23rd November 2016

**Regarding:**  
**Project #:1010550 Case #:16EPC-40040**  
**Official Notice of Decision dated November 14, 2016**  
**Conditions of Approval and Comments Response**

1 REFUSE ENCLOSURE PLAN
Scale: 1/4" = 1'-0"

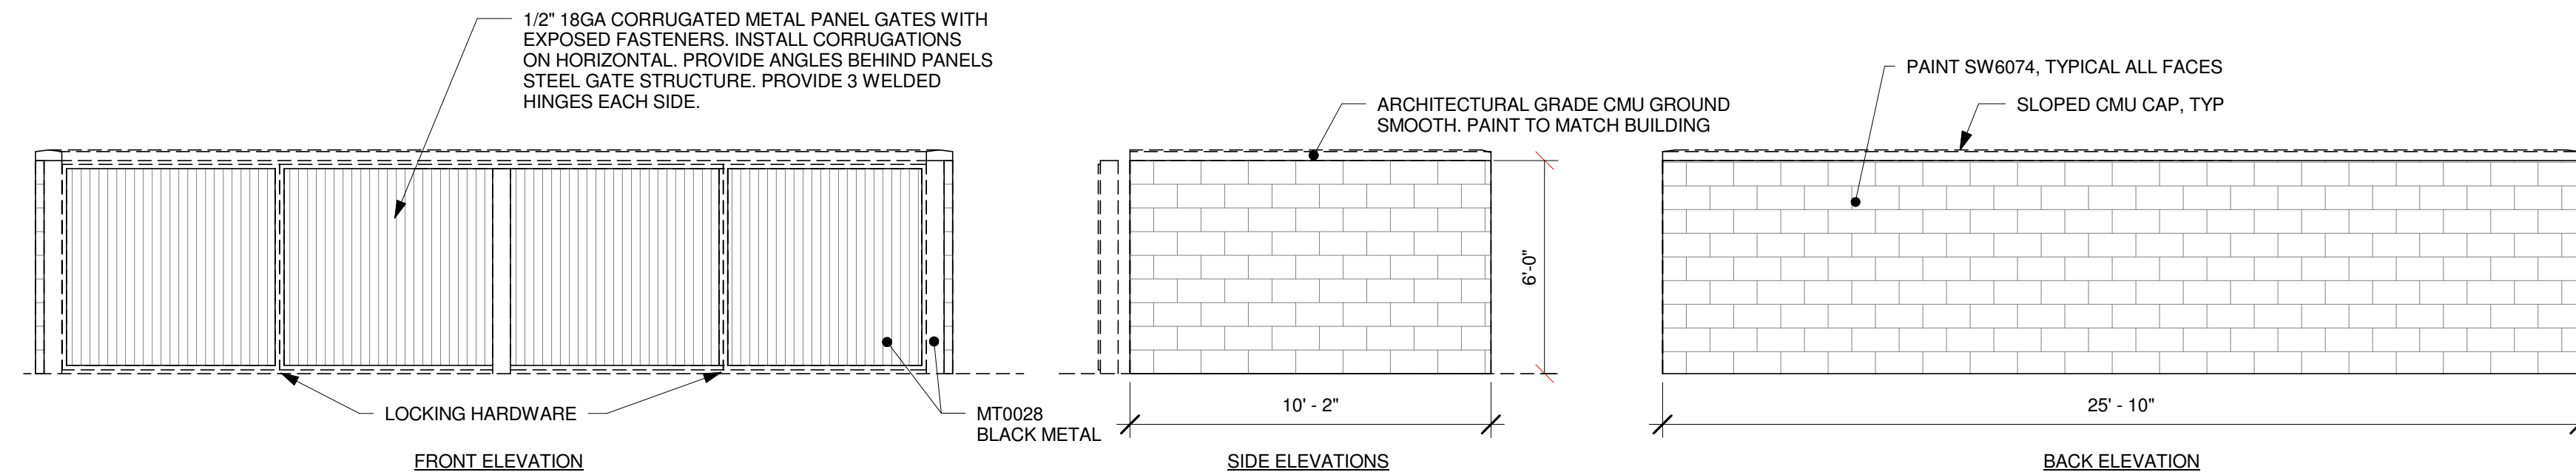
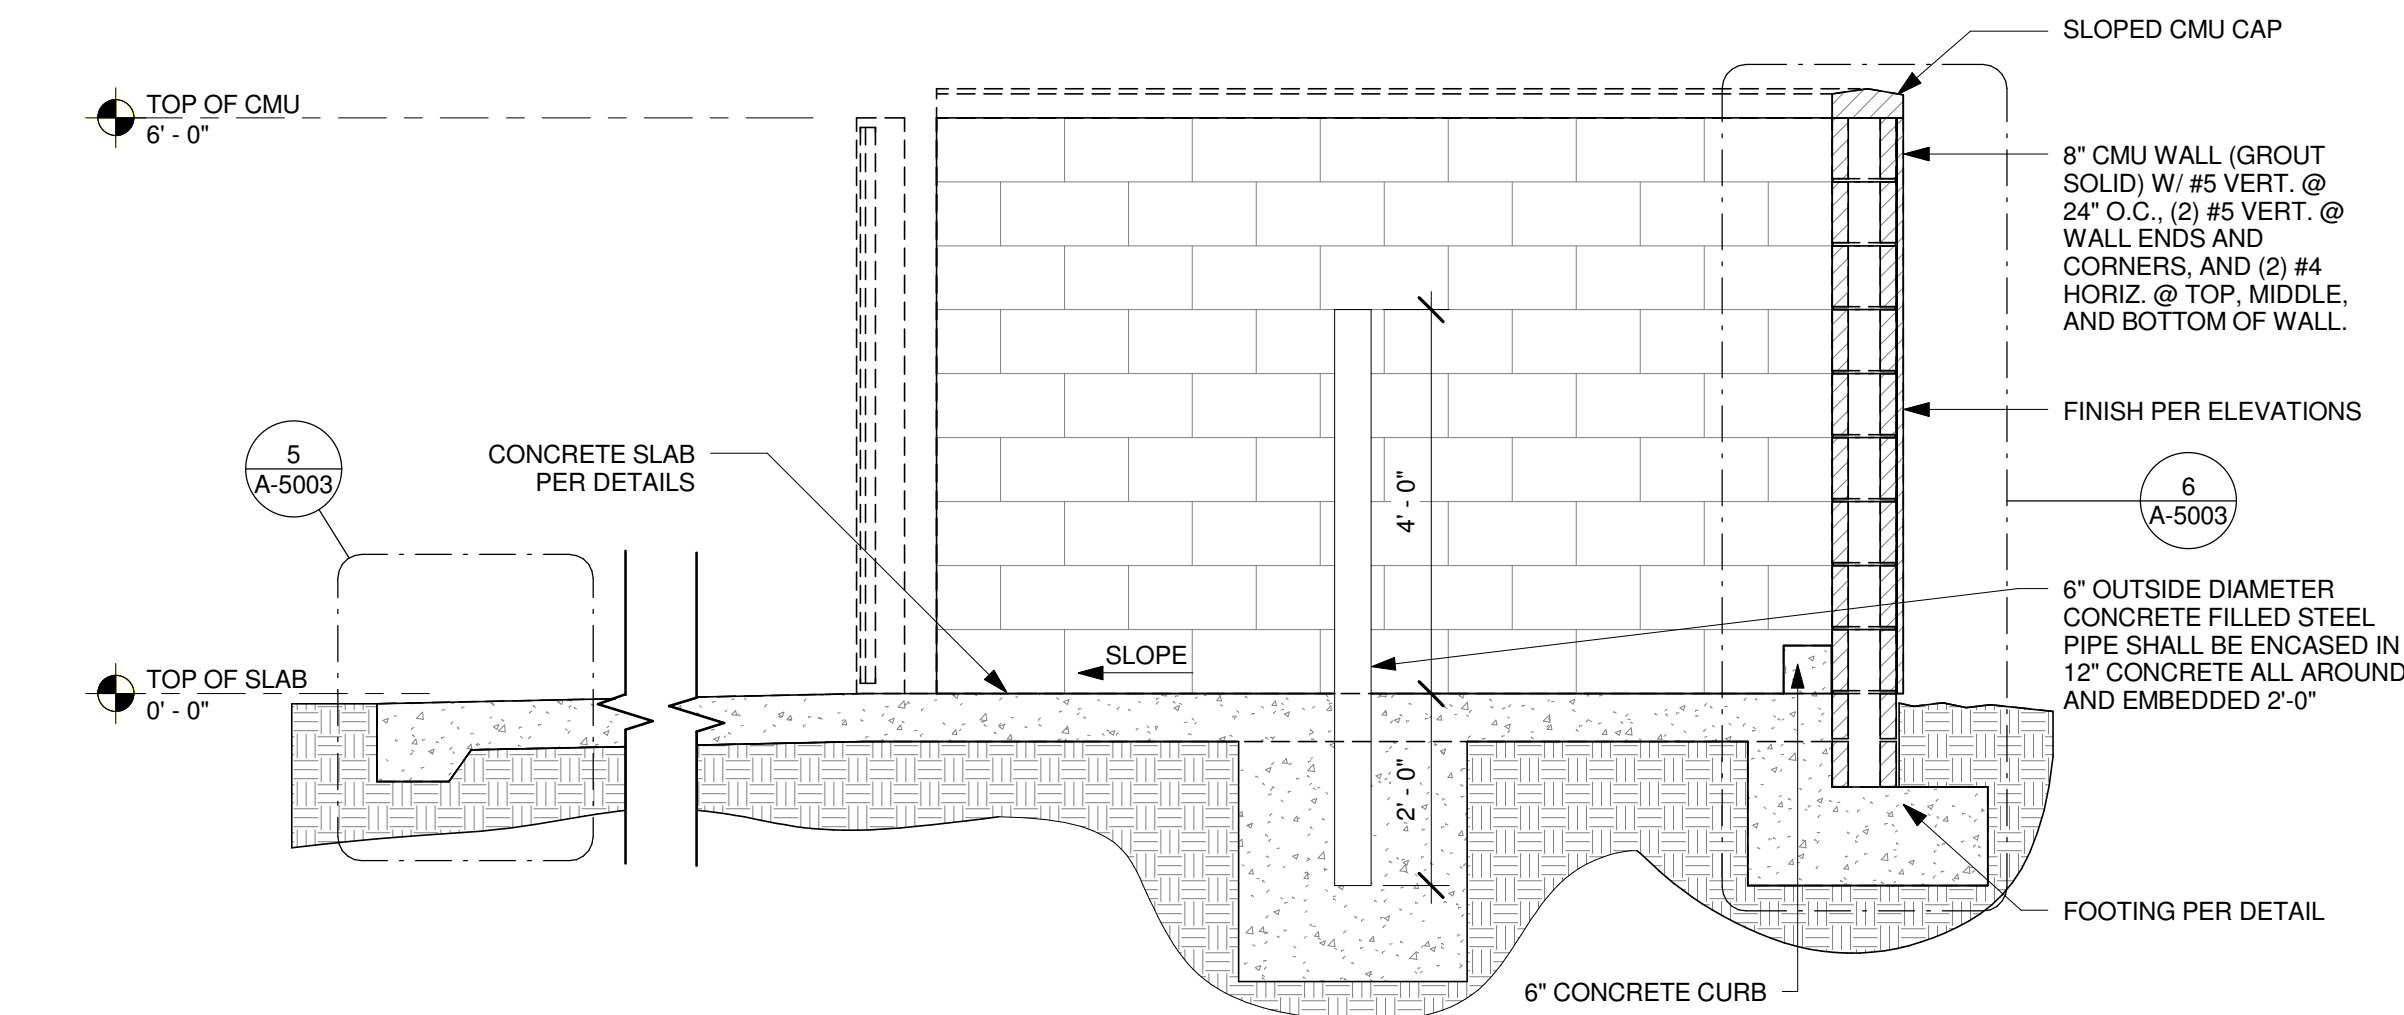
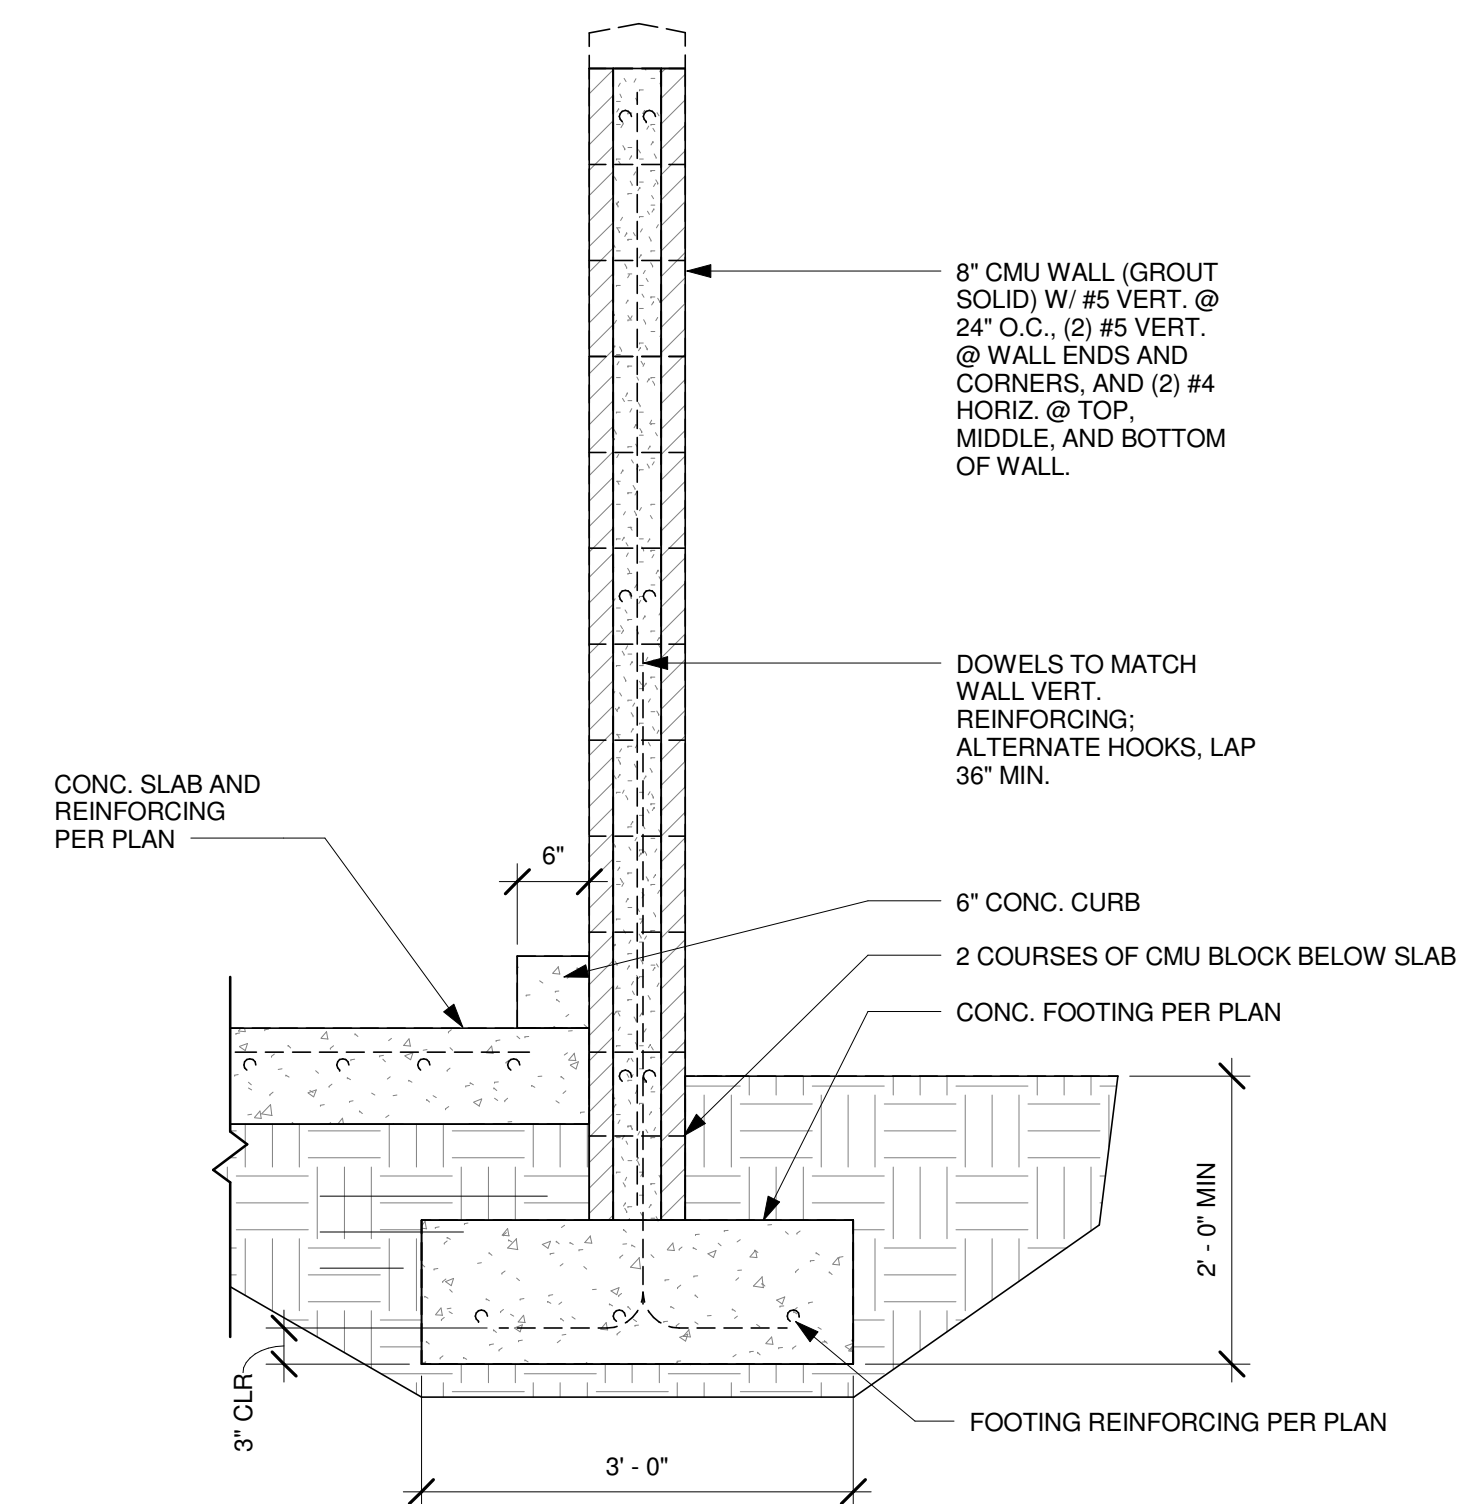
6. Conditions of Approval from City Refuse Division:
- a. Refuse enclosure enlarged and relocated to provide more direct access to bins. Refer to sheet A-1002. City specifications standards used to detail refuse enclosure. Refer to sheet A-5003 for details.

L1.00

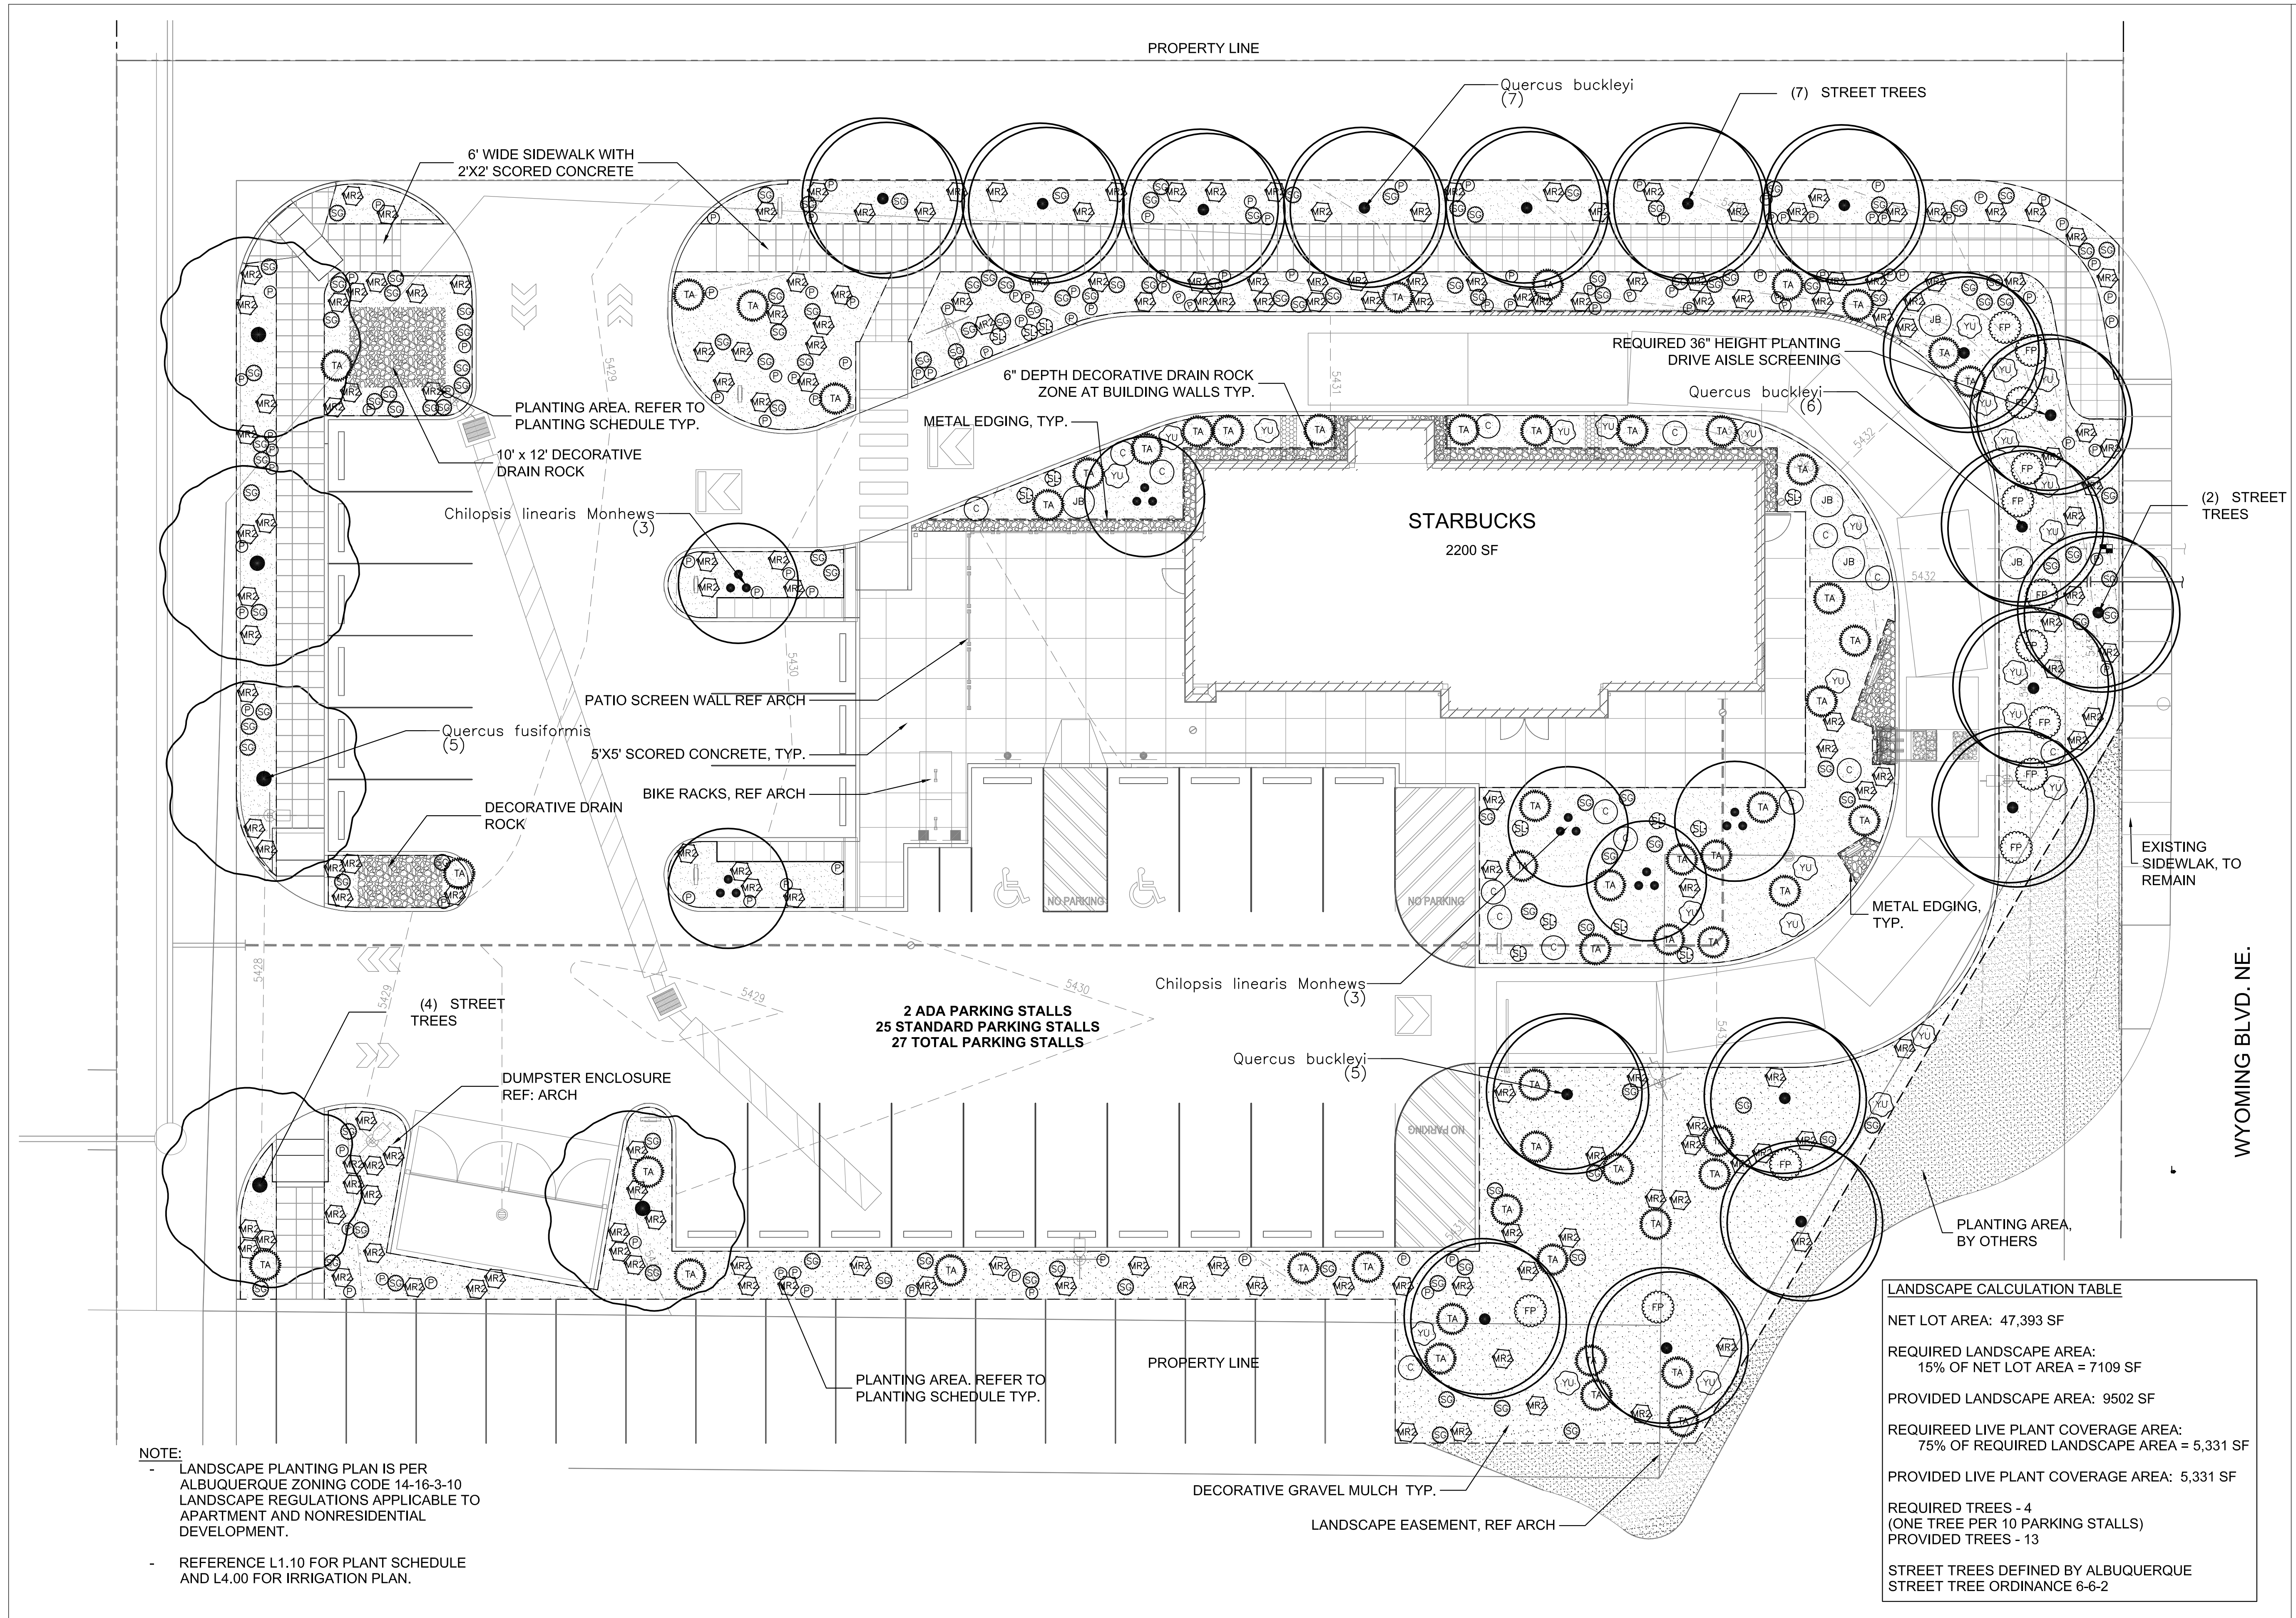
3. Refer to sheet A-1002 note 20 for modification including requested text.
4. Refer to notes 5 and 6 on sheet L1.10 for notes requested.
  - a. In addition the Landscape Calculation table on sheets L1.00 and L1.10 has been updated per site condition changes and to reflect % calculations.
